## **Development Facilitation Team (DFT) – Review Comments**

**Project No: PR-2021-005151**

### **Application For: SD-2023-00213-Final PLAT (DHO)**

DRB Project Number: 2021-005151  
Paradise Heights – Golf Course Rd

Plat of  
**Tracts D-1-A, D-1-B, D-1-C and D-1-D**  
**Paradise Heights, Unit 1**  
 Section 1, Township 11 North, Range 2 East, N.M.P.M.  
 Albuquerque, Bernalillo County, New Mexico  
 March 2023

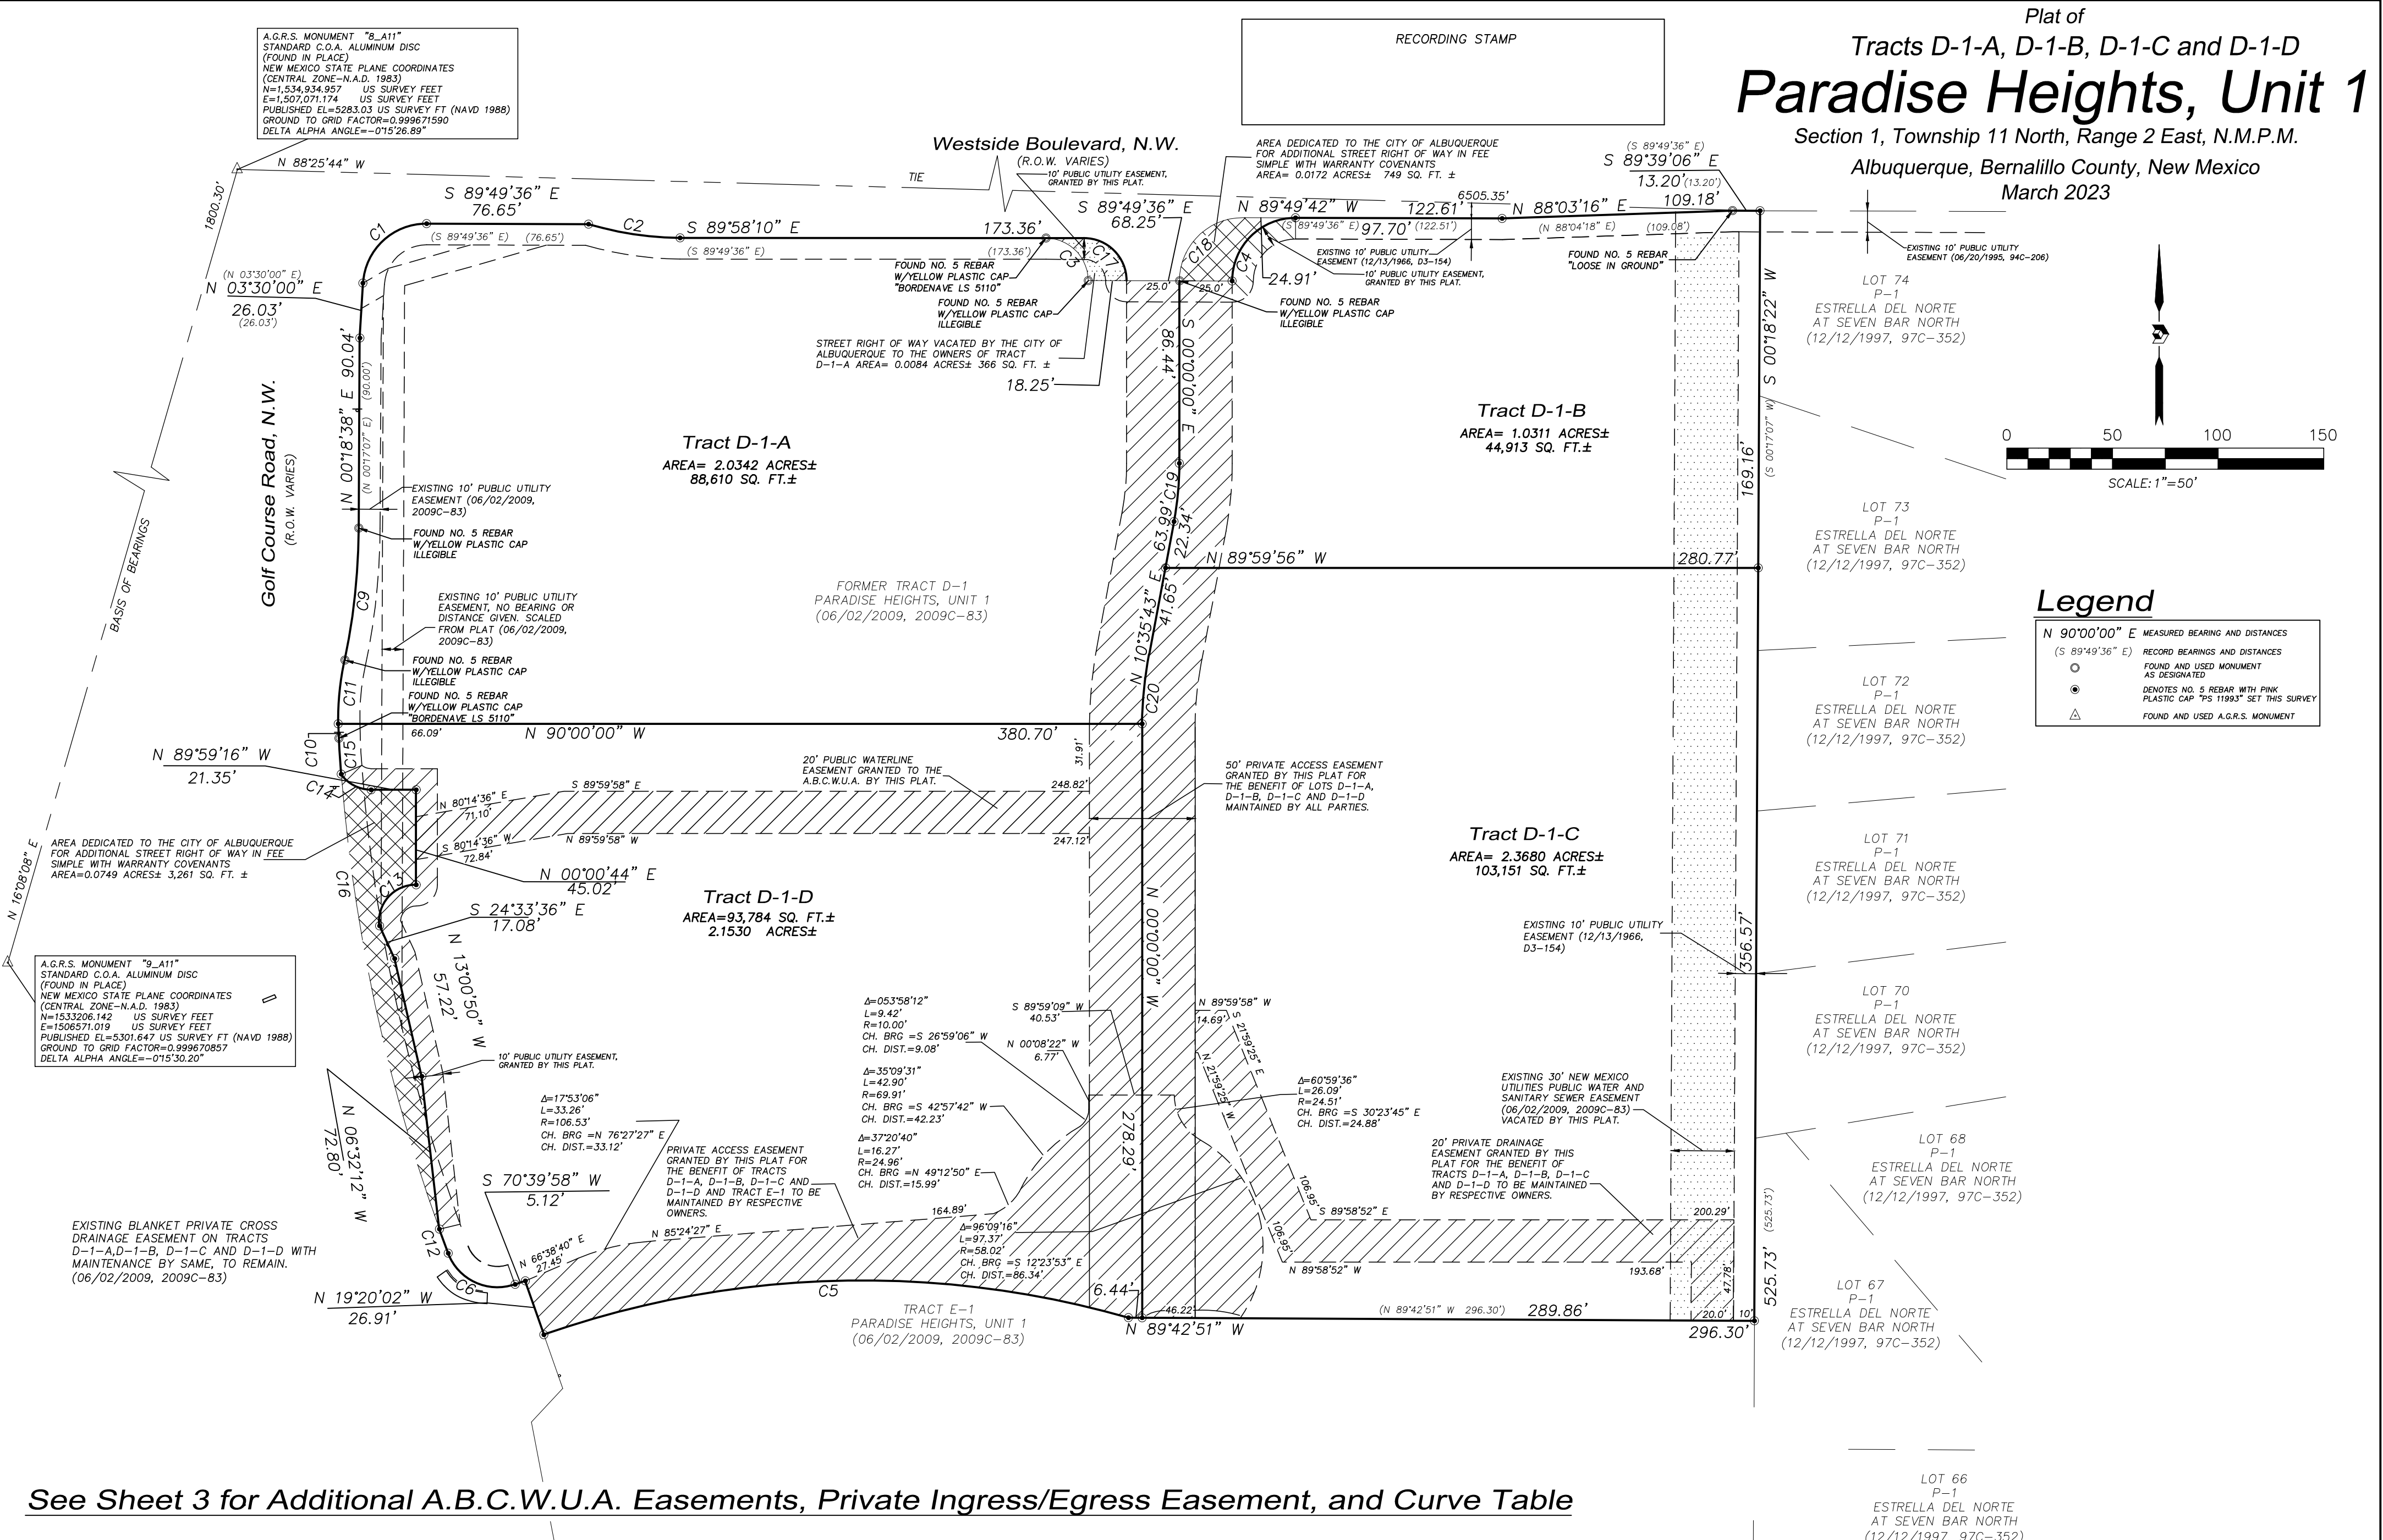
- Please confirm if the lot sizes and/or layouts for the Final Plat has/have been revised from the Preliminary Plat approved at the August 23, 2023 DHO meeting per PR-2021-005151 / SD-2023-00124: it appears that Tract D-1-A and Tract D-1-D feature minor lot size revisions between the Preliminary Plat and this Final Plat.
- The application number must be added to the Plat.
- The DXF file must be approved by AGIS, and the approval email from AGIS must be submitted prior to final sign-off from Planning should the Plat be approved by the Development Hearing Officer.
- Once/if the plat is approved by the DHO, the date of DHO approval must be added to the plat prior to final sign-off of the plat.
